Recommendation Report for Planning Permission

REF NO: BE/102/18/PL

LOCATION: 312 Chichester Road
Bersted
PO21 5AU

PROPOSAL: Erection of 1 no. dwelling

PROJECT TITLE Proposed Development at 312 Chichester Road Bognor Regis	DRAWING TITLE Proposed Site & Location Plans		No	REVISION	DATE
	STATUS Planning Application				
	SCALE As Shown	DATE 20.03.2018			
	DRAWN BY AP	DRAWING No PA-276-02

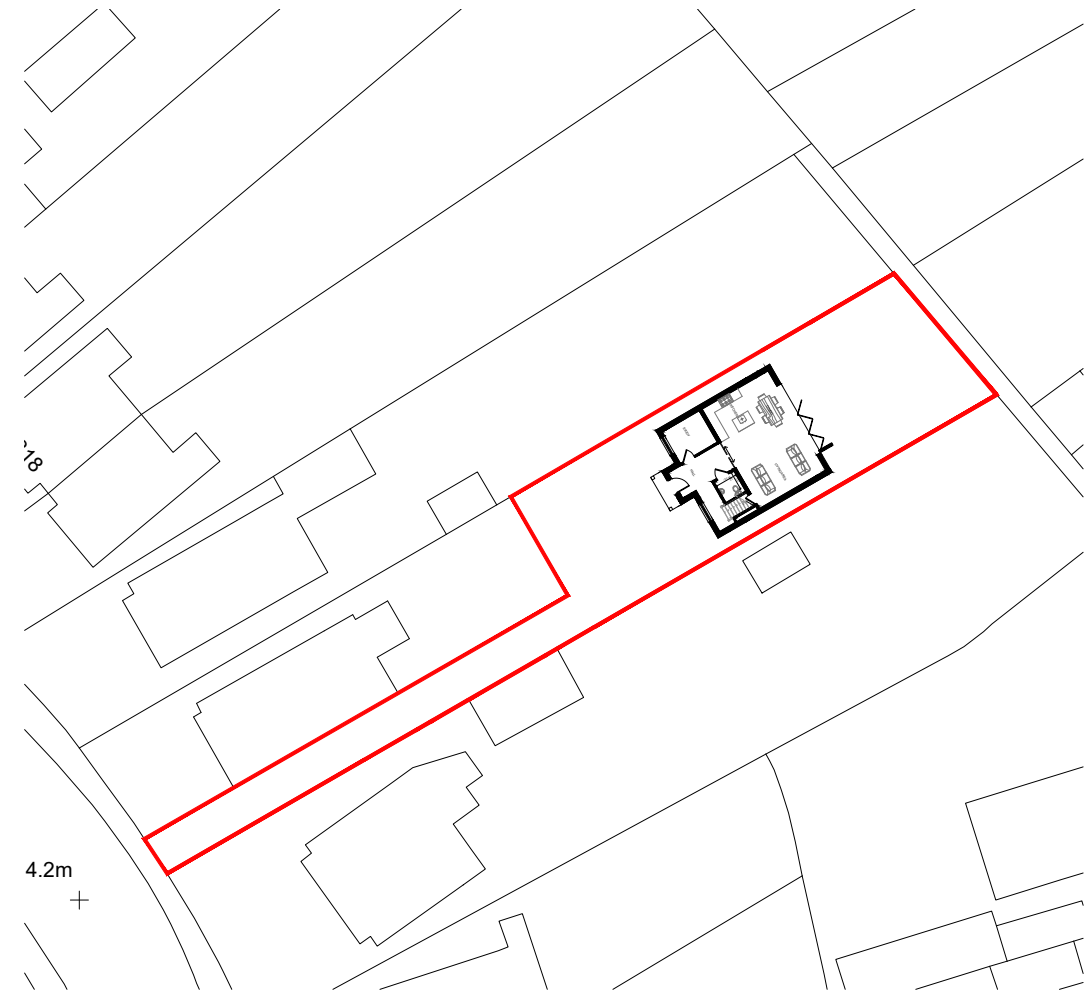
Whilst, visually, the proposed building will have limited impact on the character of the area, the creation of the vehicular access will be a form of development that is not characteristic of the area. Its exceptionally cramped proportions - squeezed between two dwellings - to create vehicular access to the rear of existing dwellings will result in a form of development out of character with the area.

It is also necessary to consider whether the intensification and extension of the access driveway would be harmful to the amenities of the two houses either side (nos. 310 and 312) or in respect of the parking area, to the amenities of 314. It is accepted that there is already access down part of the side of 312 to the garage and that 310 also has a driveway and garage on their side. However, the proposal will extend the driveway past the two existing houses and result in new vehicle movements to and from the new house including by delivery vehicles. The driveway is proposed to be only around 2.7m wide where it passes between 312 and the fence to 310.

Bearing in mind, the width of a standard parking space (2.4m), this does not give much room for any amenity planting or new acoustic fencing to either side of the driveway which could help to alleviate any disturbance issues. It also means that conflict may occur if a vehicle is entering whilst another (or a pedestrian) is exiting the site. Such a situation could result in vehicles having to wait with engines running only a few feet from the adjacent houses. It is considered that the extension of the driveway into the site, its narrow width and its intensification will all result in harm to the two neighbouring properties by reason of noise and general disturbance. This will be in conflict with policies D DM1 and QE SP1 of the Arun Local Plan and the guidance on good design (paragraph 127) within the National Planning Policy Framework.

- 1 The proposed extension and intensification of the driveway into the rear of the plot will give rise to harm to the character and appearance of the streetscene and in respect of noise and disturbance to the living conditions and amenities of the occupiers of both 310 and 312 Chichester Road in conflict with policies D DM1, D SP1 and QE SP1 of the Arun Local Plan and the guidance on good design within the National Planning Policy Framework.
